REF NO: Y/15/17/DOC

LOCATION: Land to the North of John Turner Phormiums, Lake Lane, Barnham, PO22 0AL

PROPOSAL: Application for approval of details reserved by condition imposed under Y/64/16/PL relating to conditions 5-landscape scheme for HGV parking site, 6-landscape scheme along southern boundary, 7-Site Management Plan & 10-light appliances.

Drawing No:	Arbtech LP 02	Rev:	
Date:	June 2017	Scale:	1:200 @ A1
Drawn:	MGM

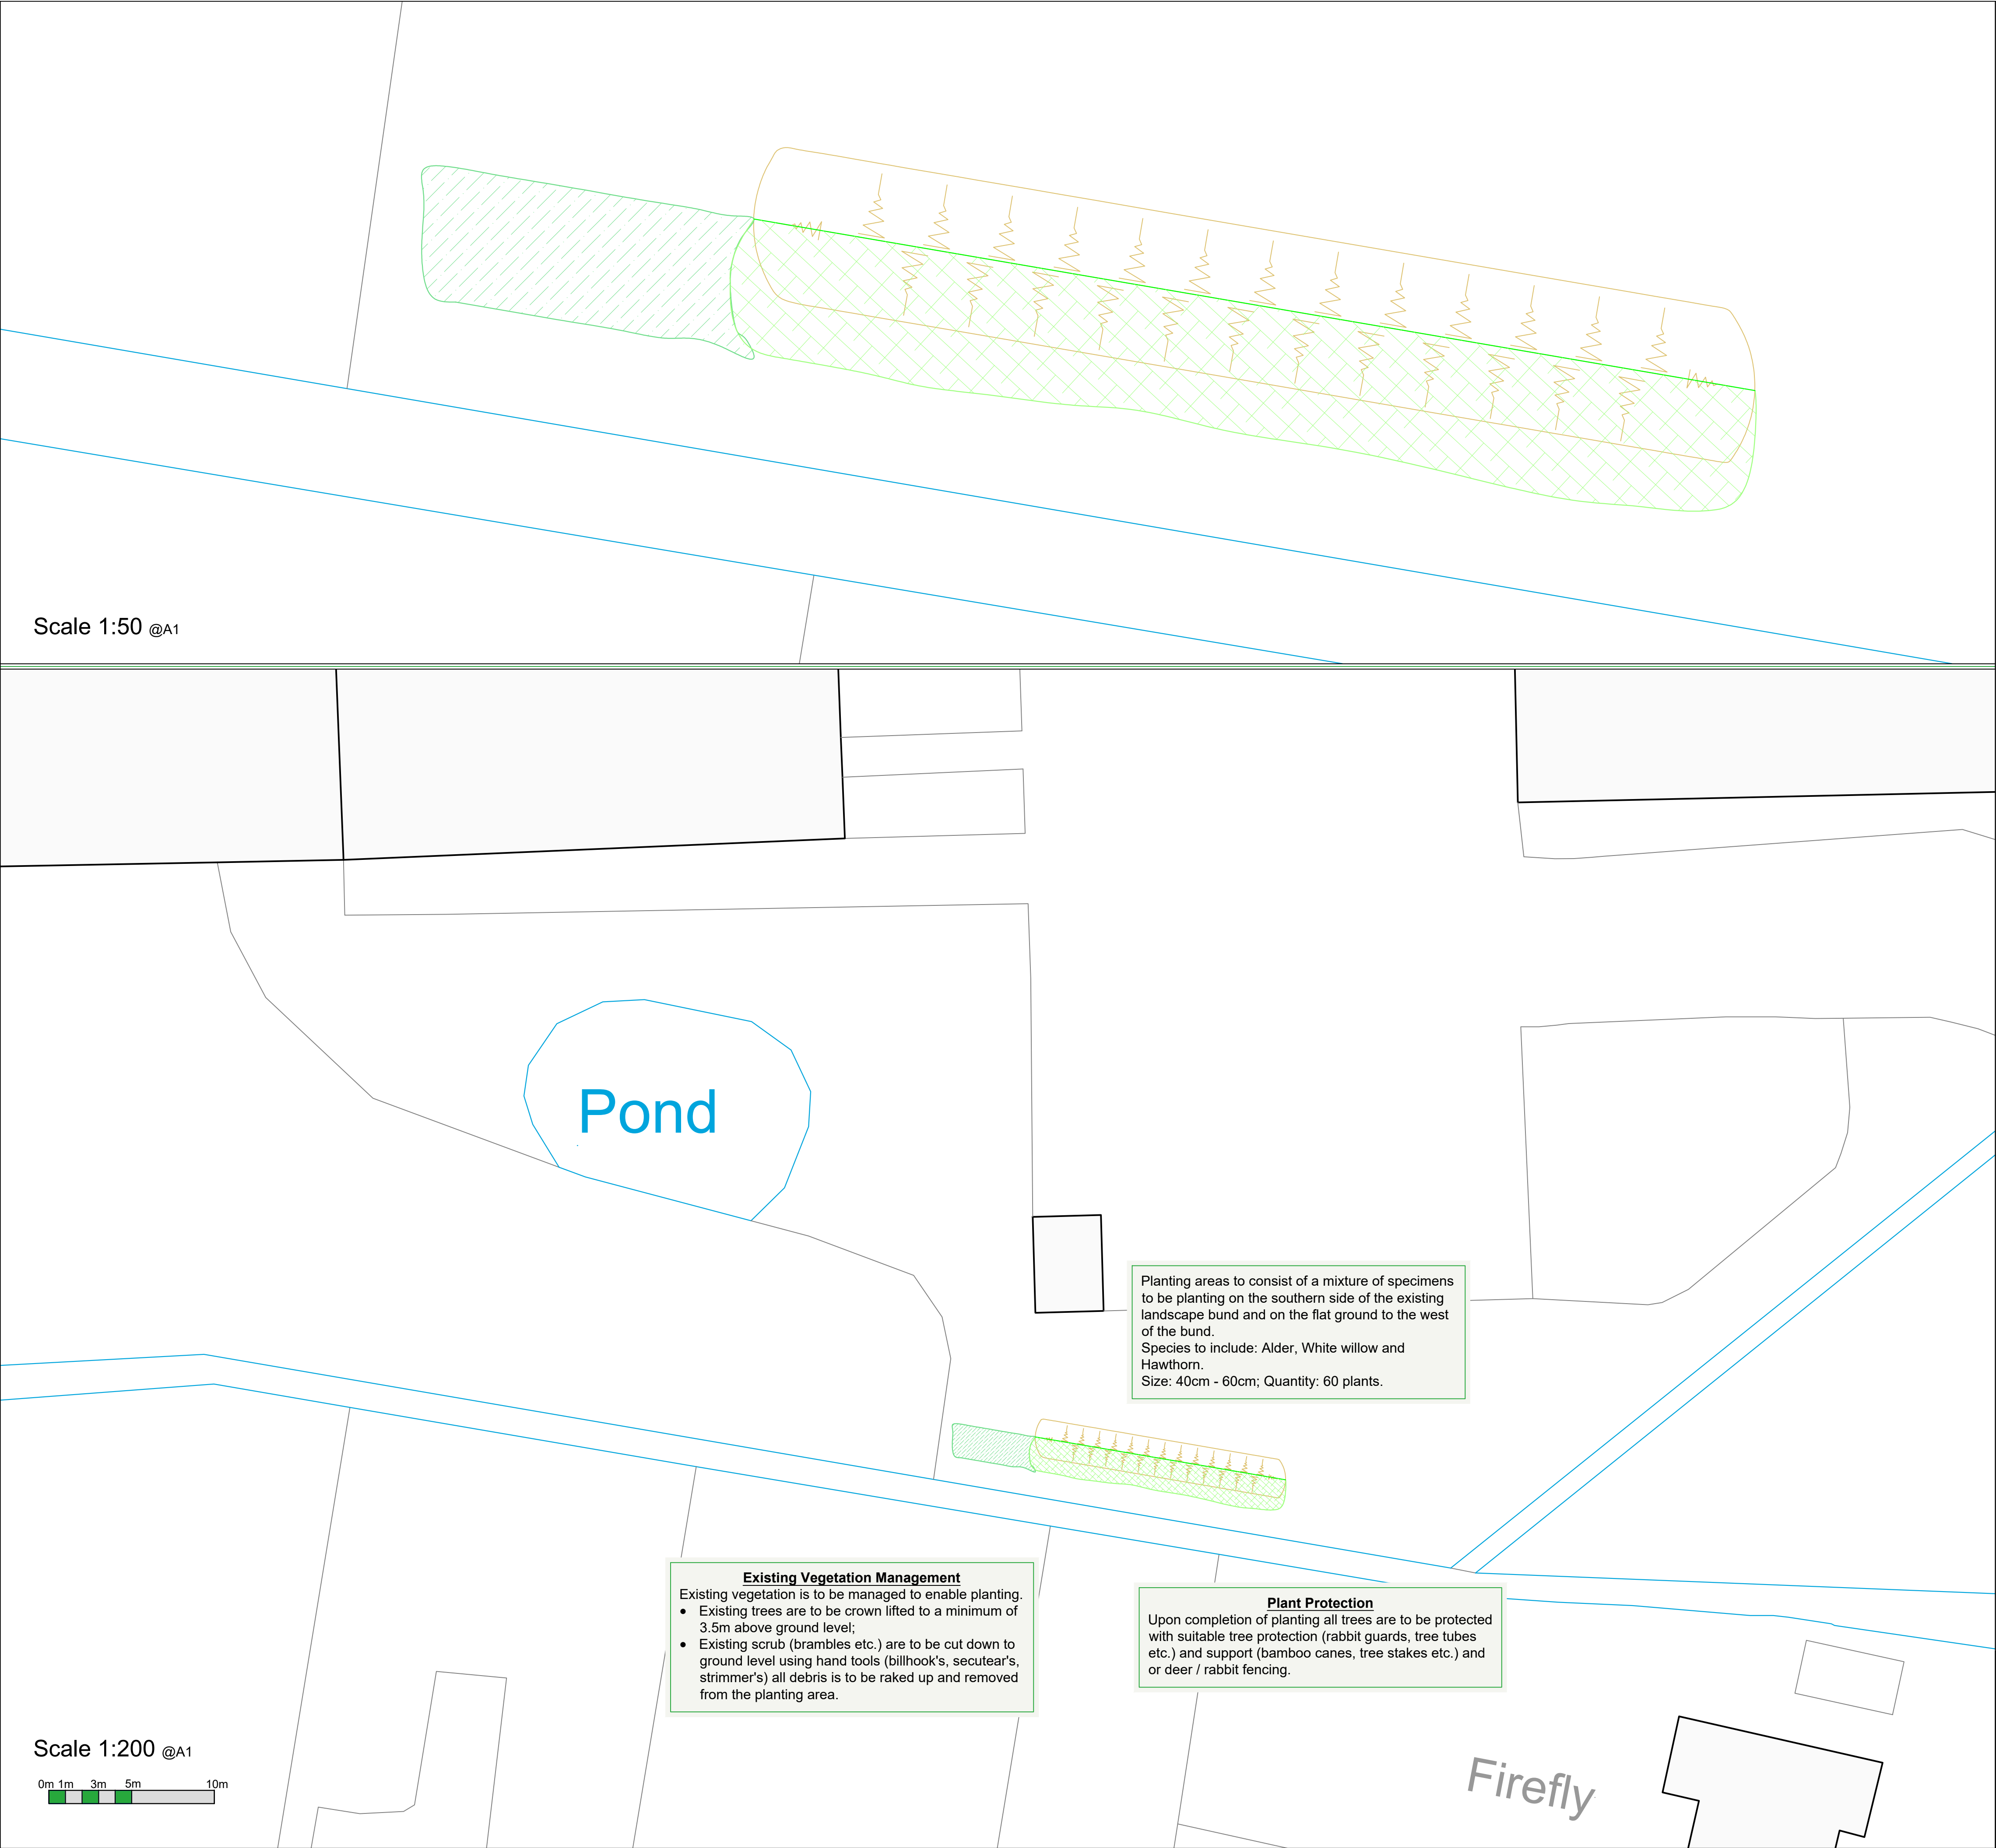
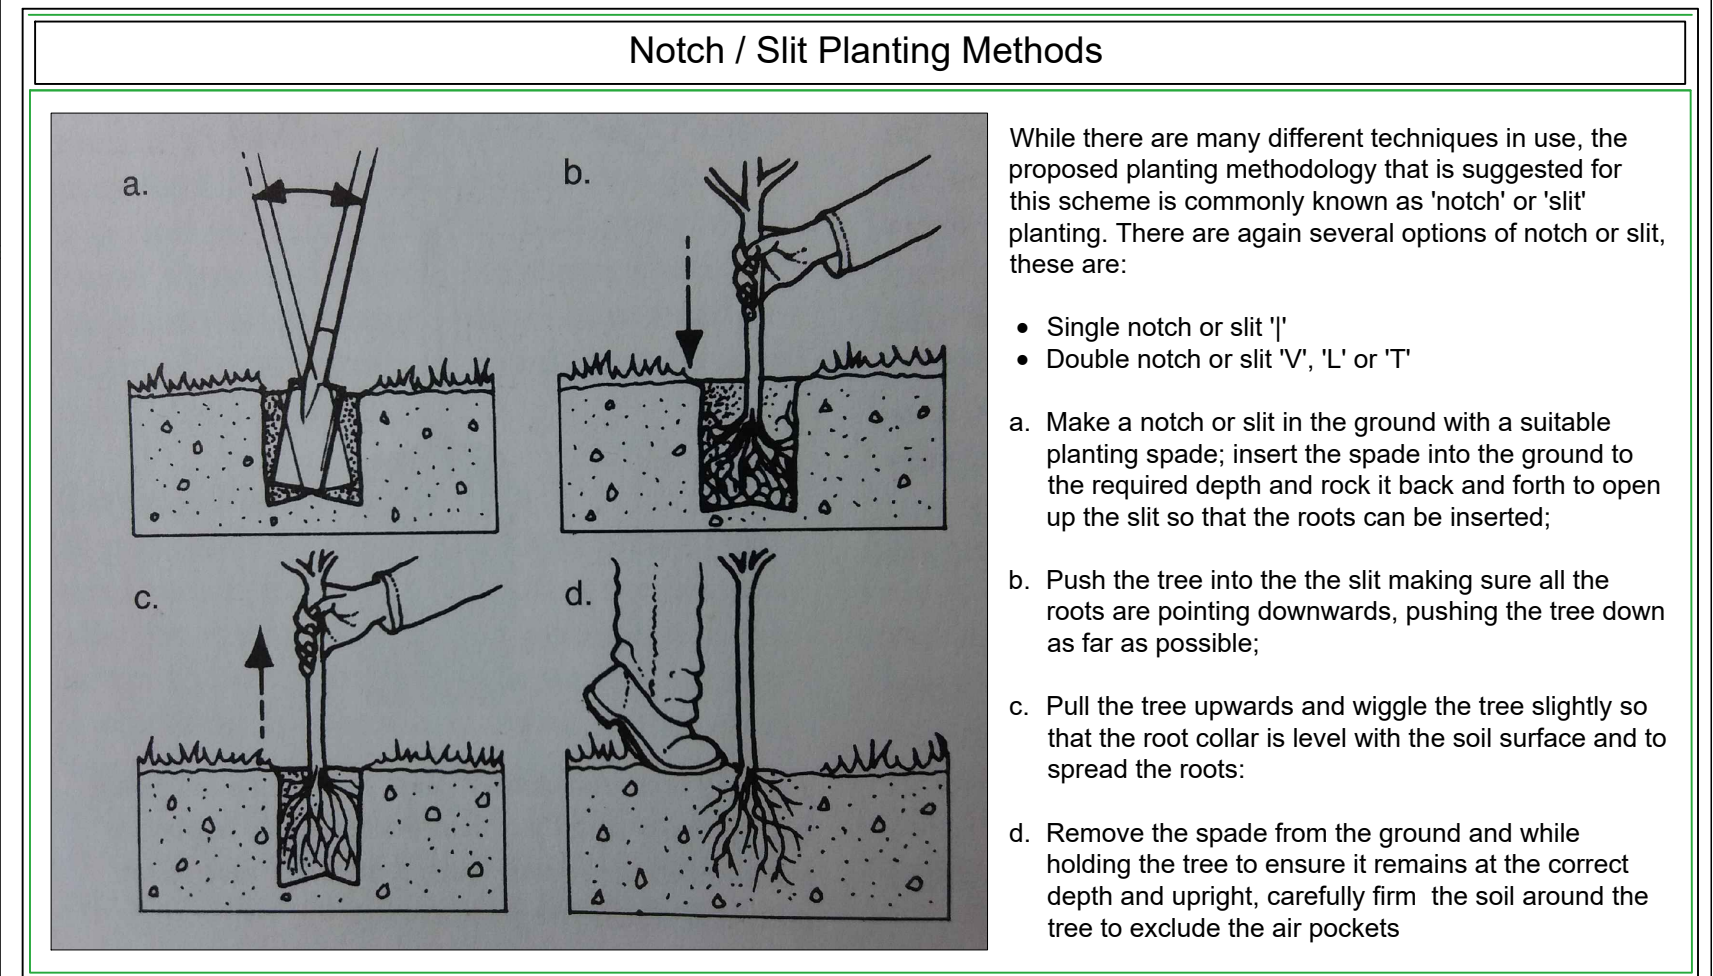
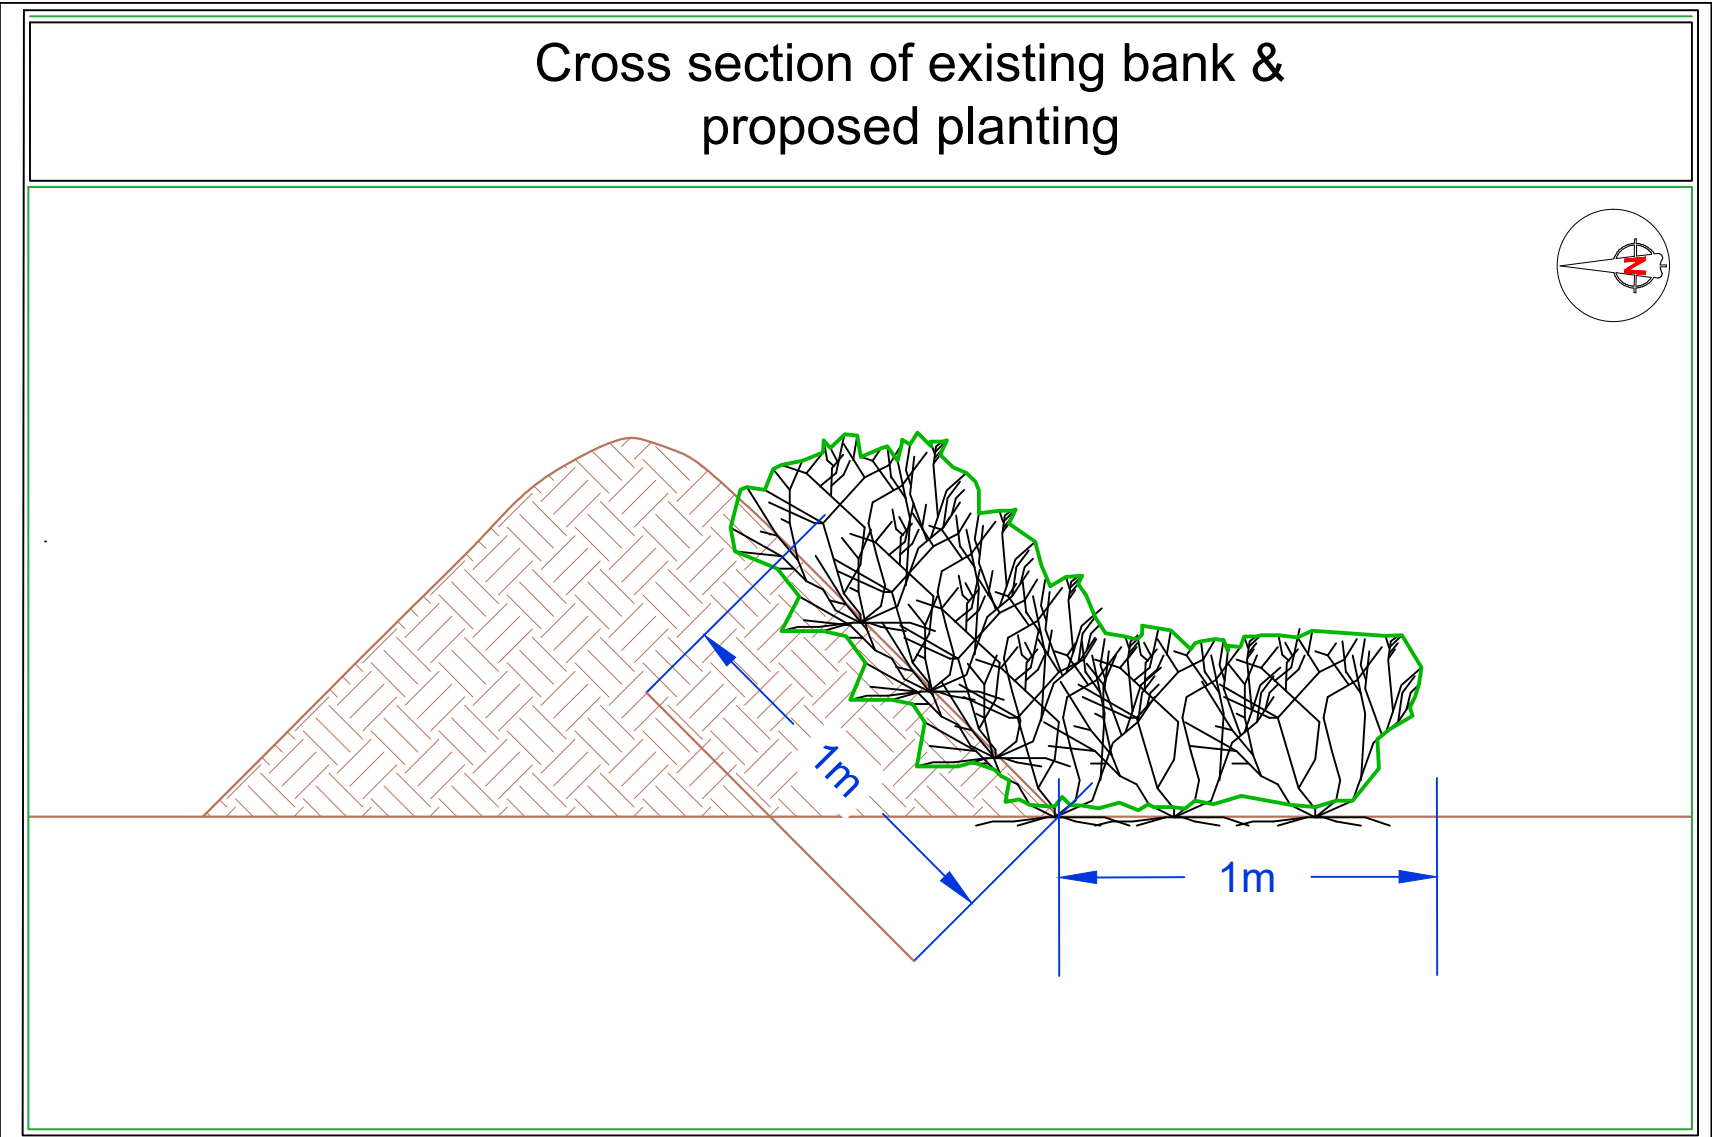
Local residents have raised concern as to the proposed landscaping to the existing Consolidation Centre site. Their concerns are essentially that the proposed additional planting will not mitigate any noise from the site (objections (10) & (12). Objection (13) has been answered by the submission of the revised plan. The answer to objection (11) is no, the planting scheme does not take account of existing planting within residential gardens.

The Councils Environmental Health Officer considers that the proposed planting scheme is unlikely to provide any additional noise mitigation. However, it was clear at the planning application stage that planting in this location would be unlikely to make much difference to noise levels emanating from the site. This is because, the existing acoustic fence, the existing bund and the associated planting are located next to the noise 'receiver' and not

the noise source. The request for additional landscaping was made in the knowledge that it would be unlikely to make much difference but was still reasonable given the existing gaps in the existing planting.

The submitted Landscape Scheme as detailed on Drawing Arbtech LP02 (June 2017) as supplemented by the Arbtech Report (02/03/17) has been assessed by our Landscape Officer and is considered to be acceptable.
